Application for a non-material amendment following a grant of planning permission.
 Town and Country Planning Act 1990

Proposed one 3 bedroomed detached dwelling

H07-0321-16

Added 2nd floor into roofspace

Drawing
FLOOR PLANS & ELEVATIONS .
- PROPOSED

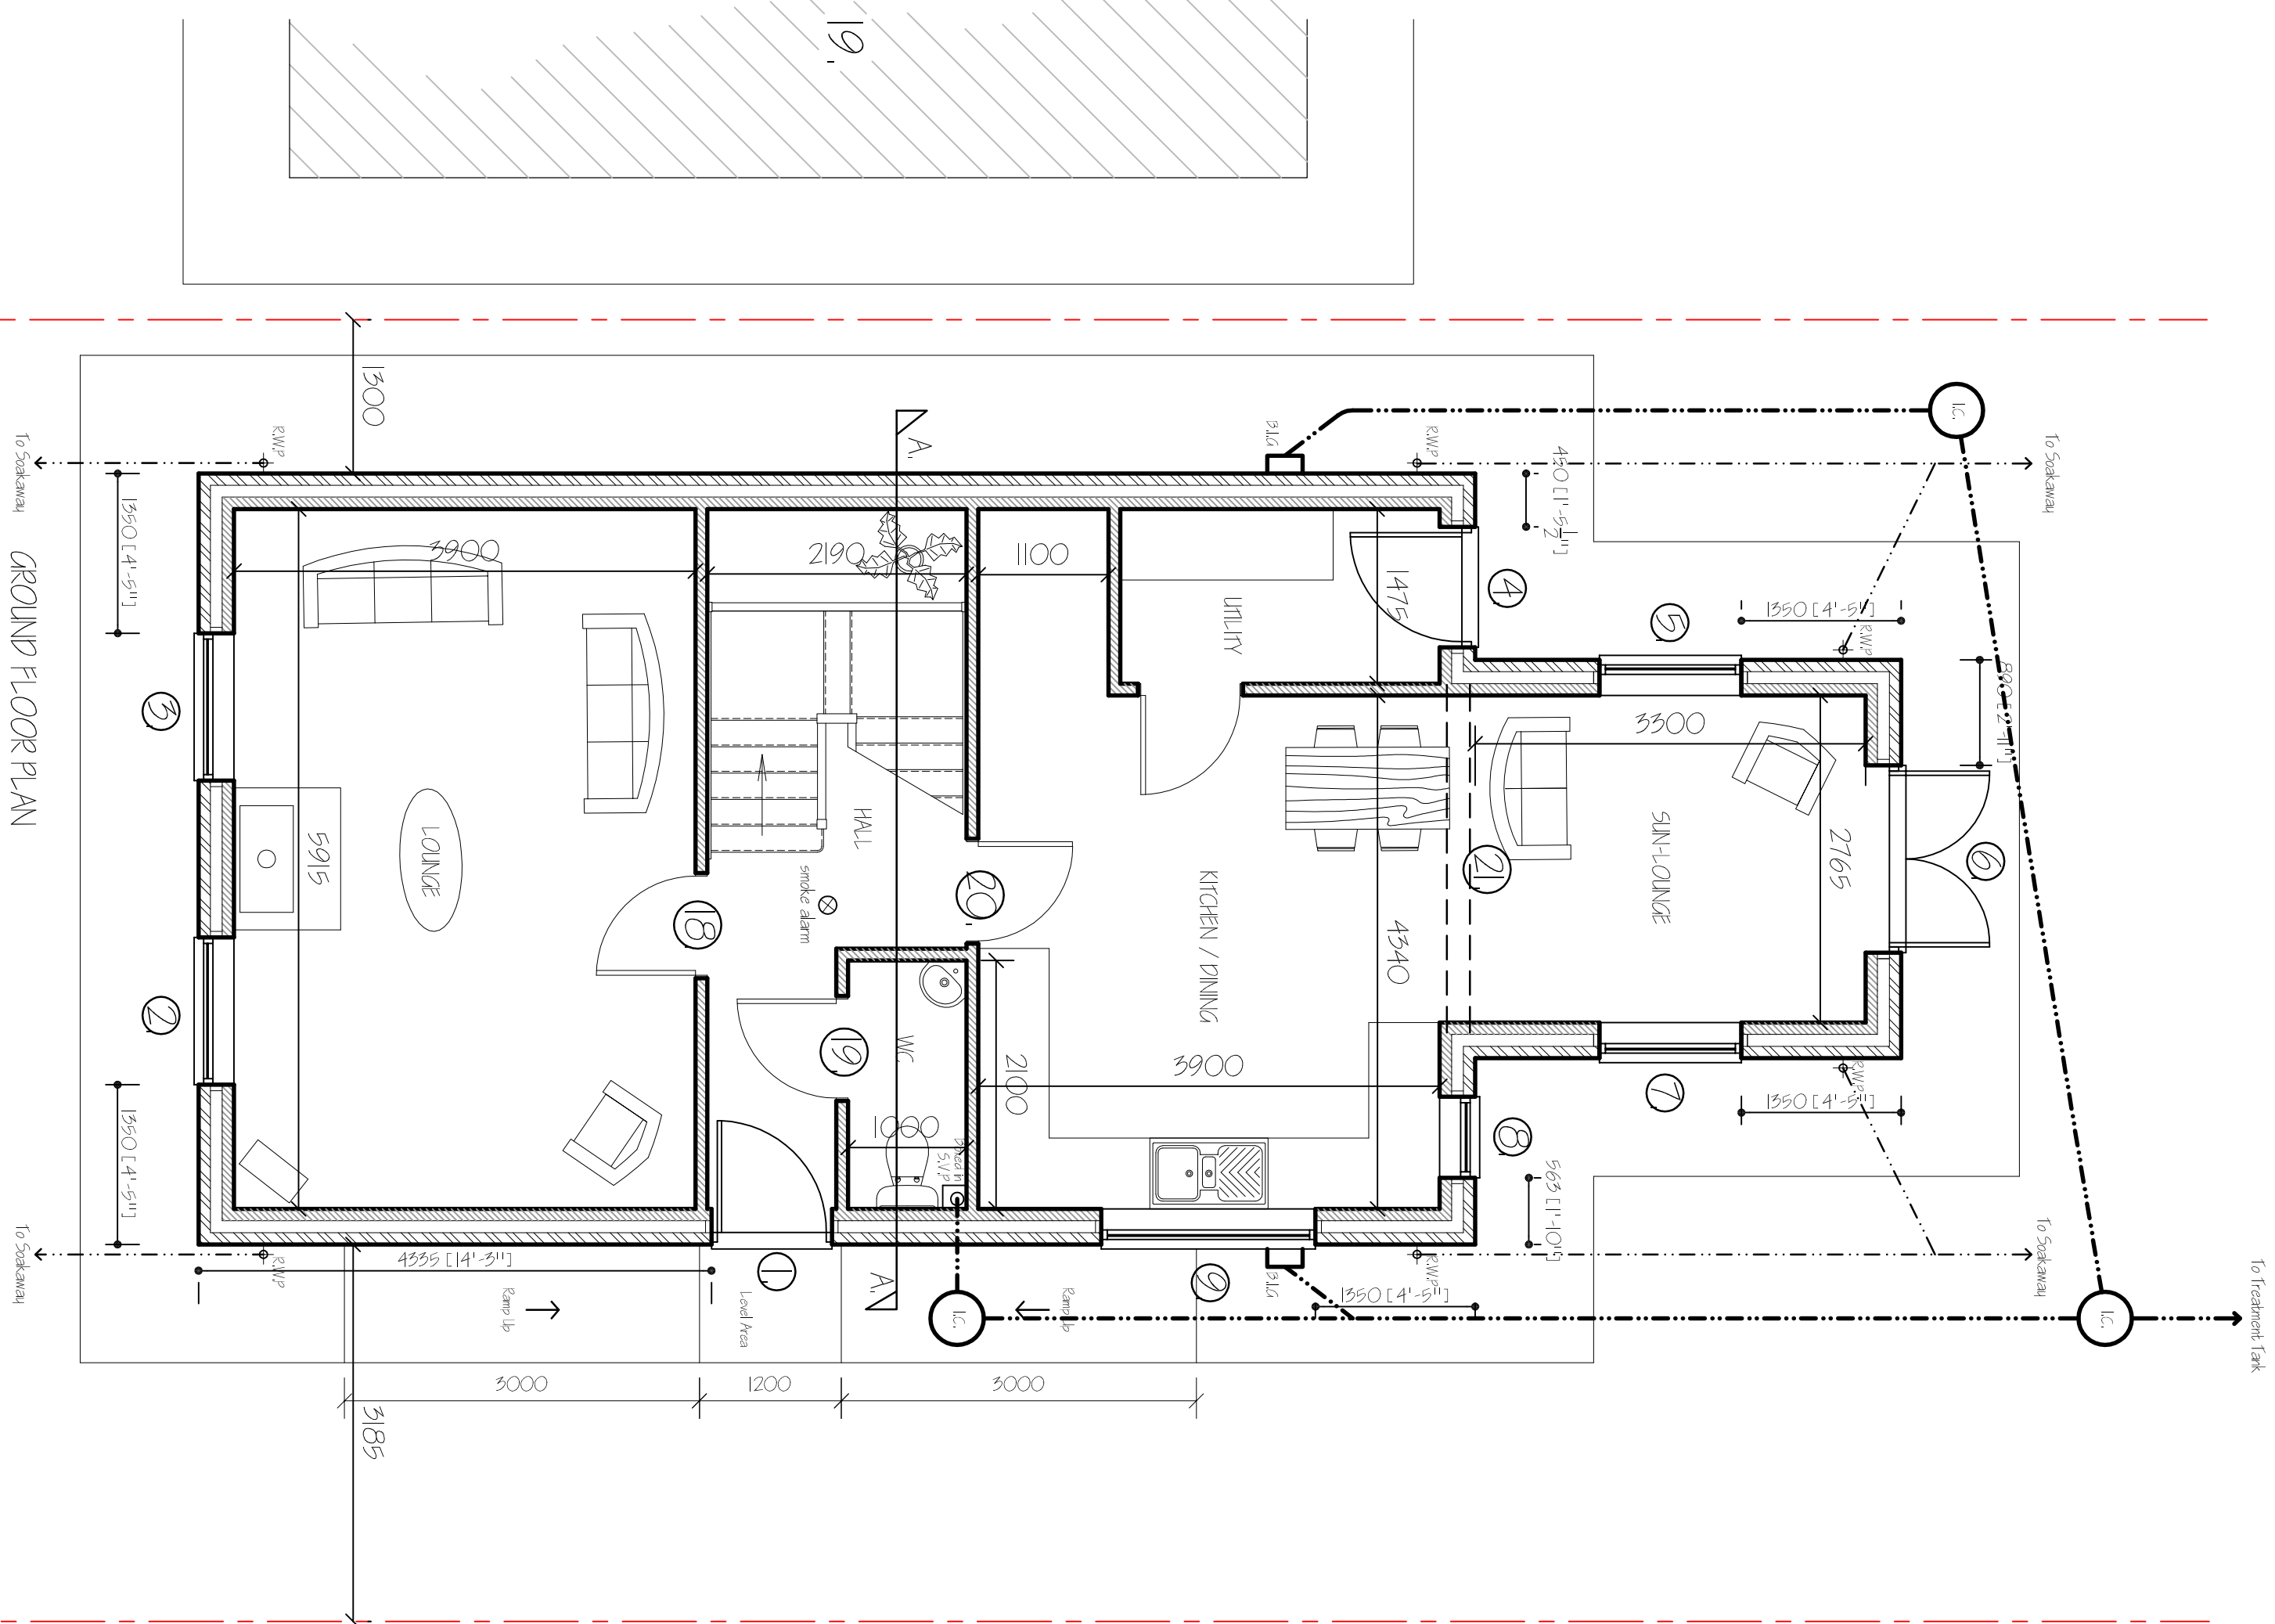
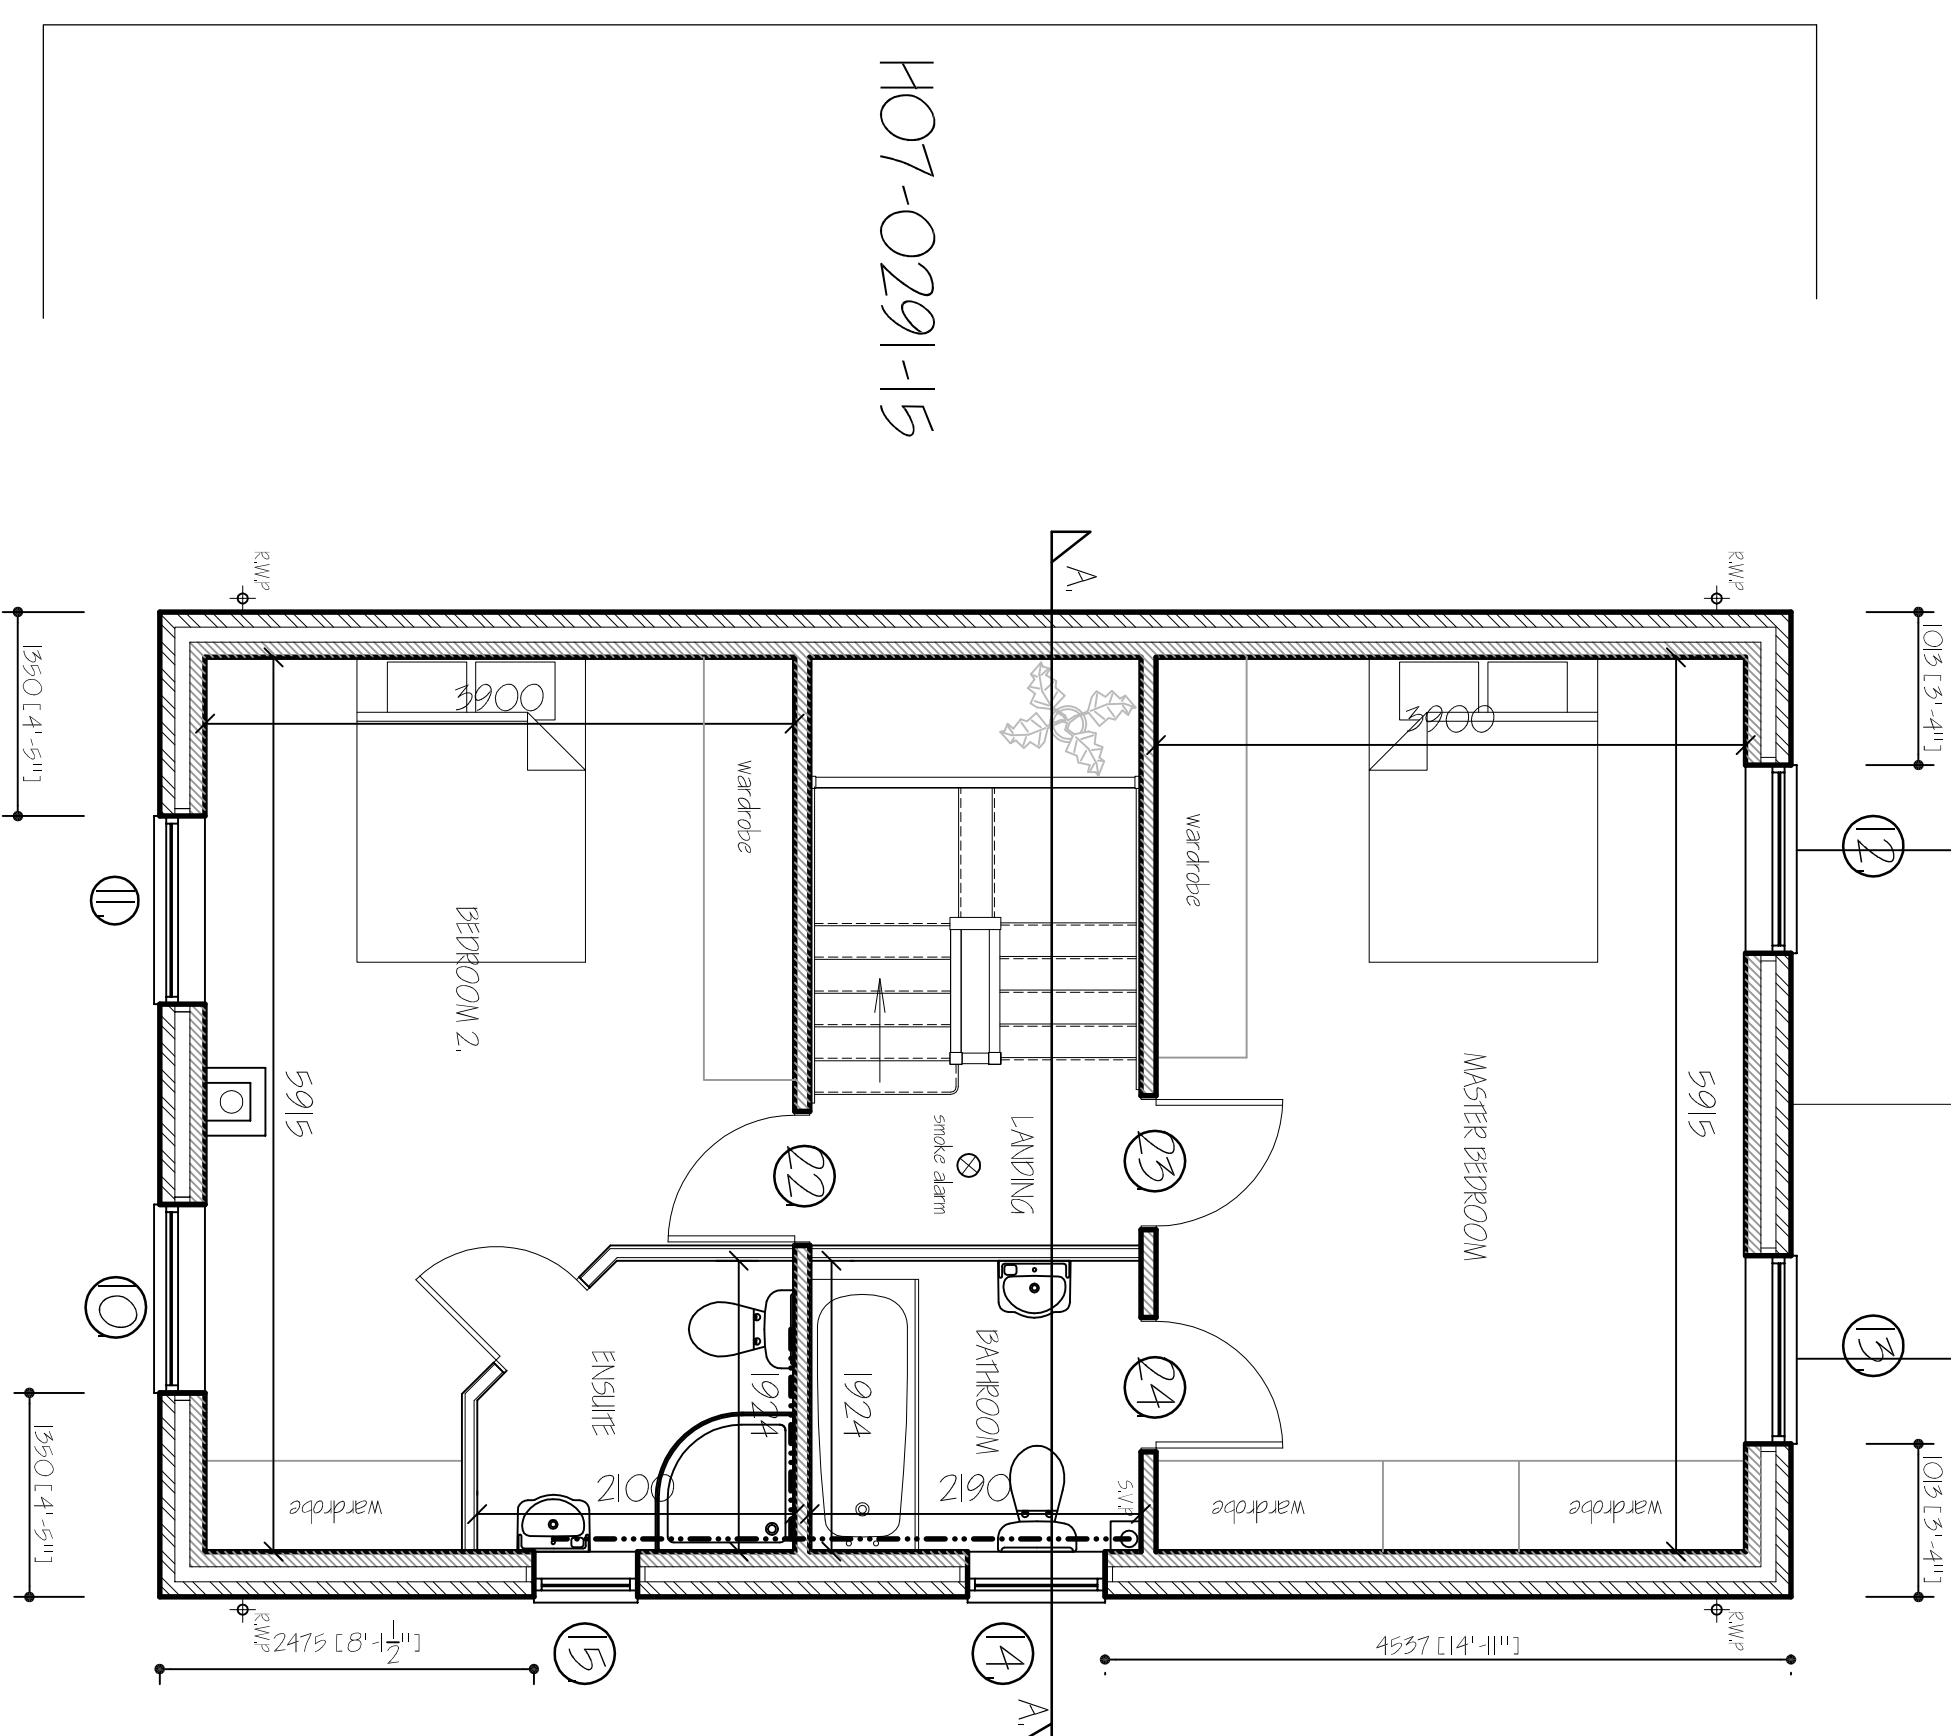
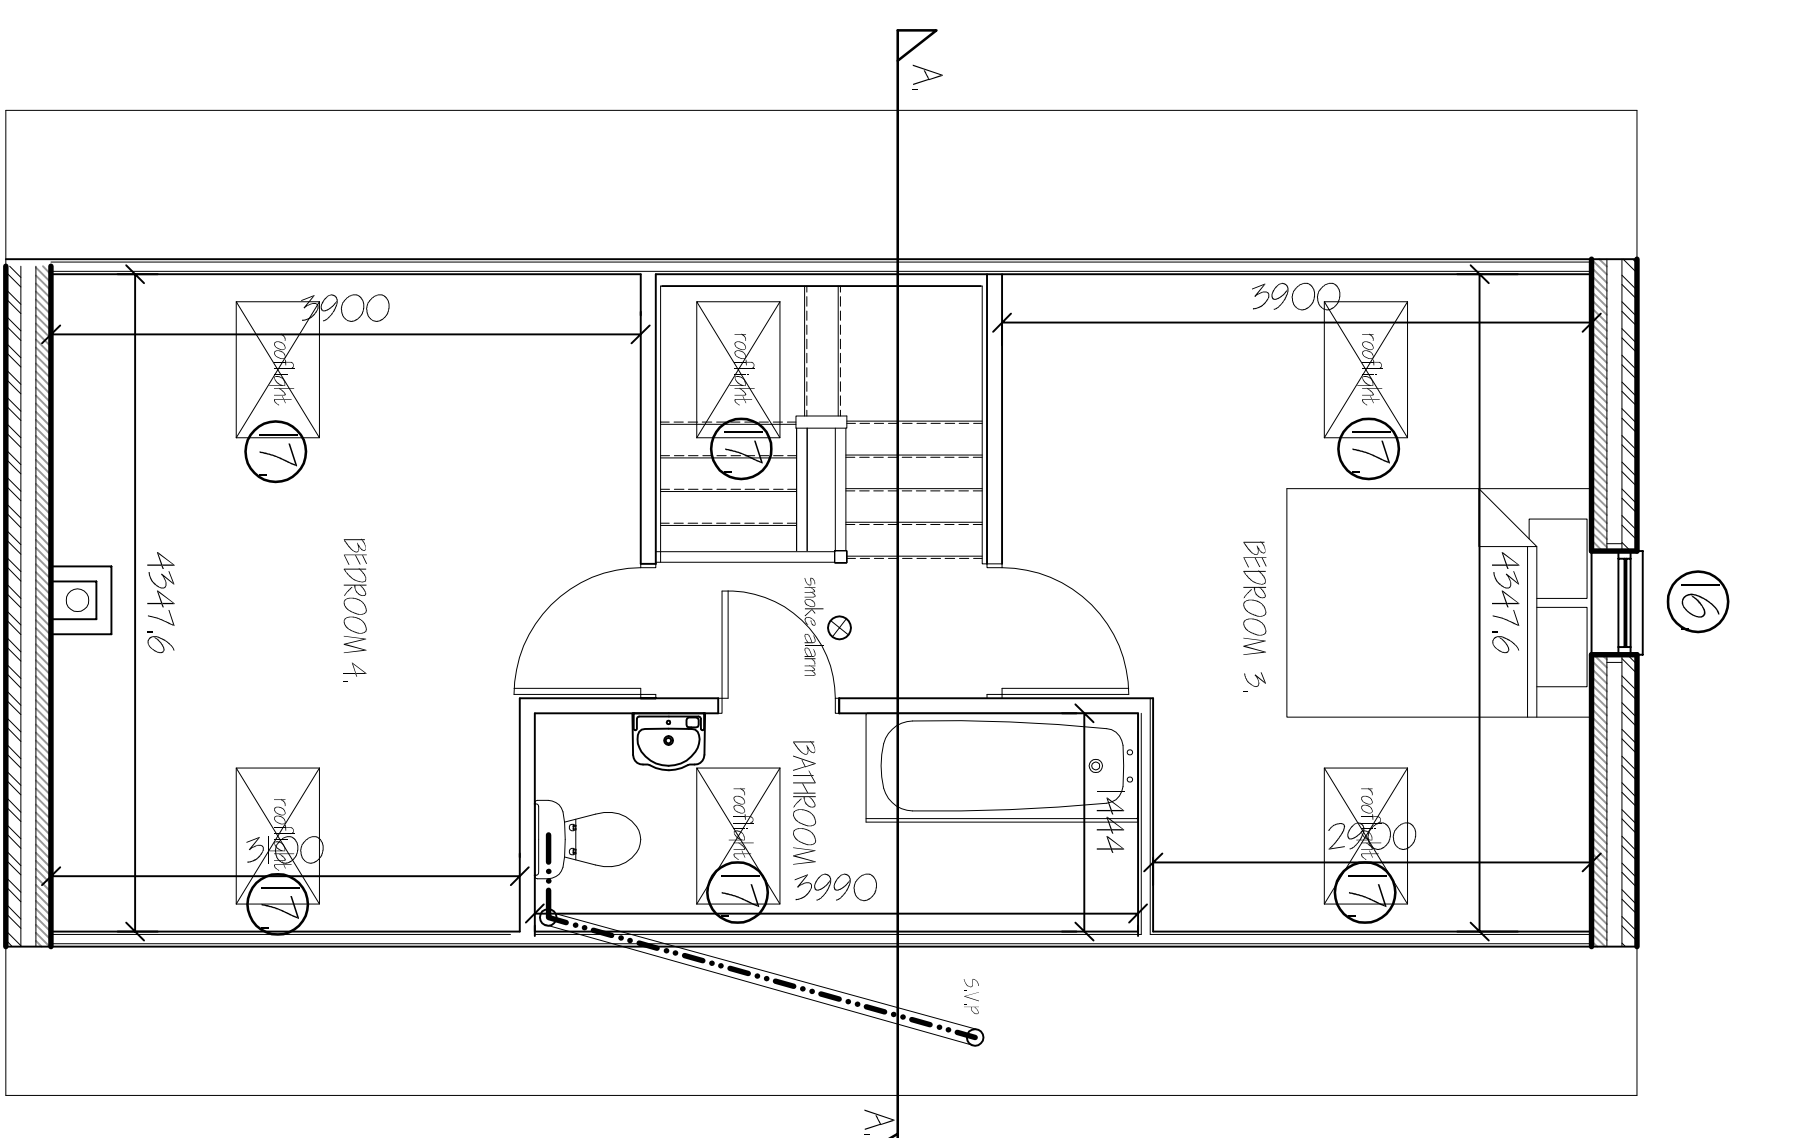
Increase roof pitch
Additional windows & roof lights added to second floor
Amended internal layout
Change en-suite windows
Change of bricks (Hoskins Old Farmhouse)
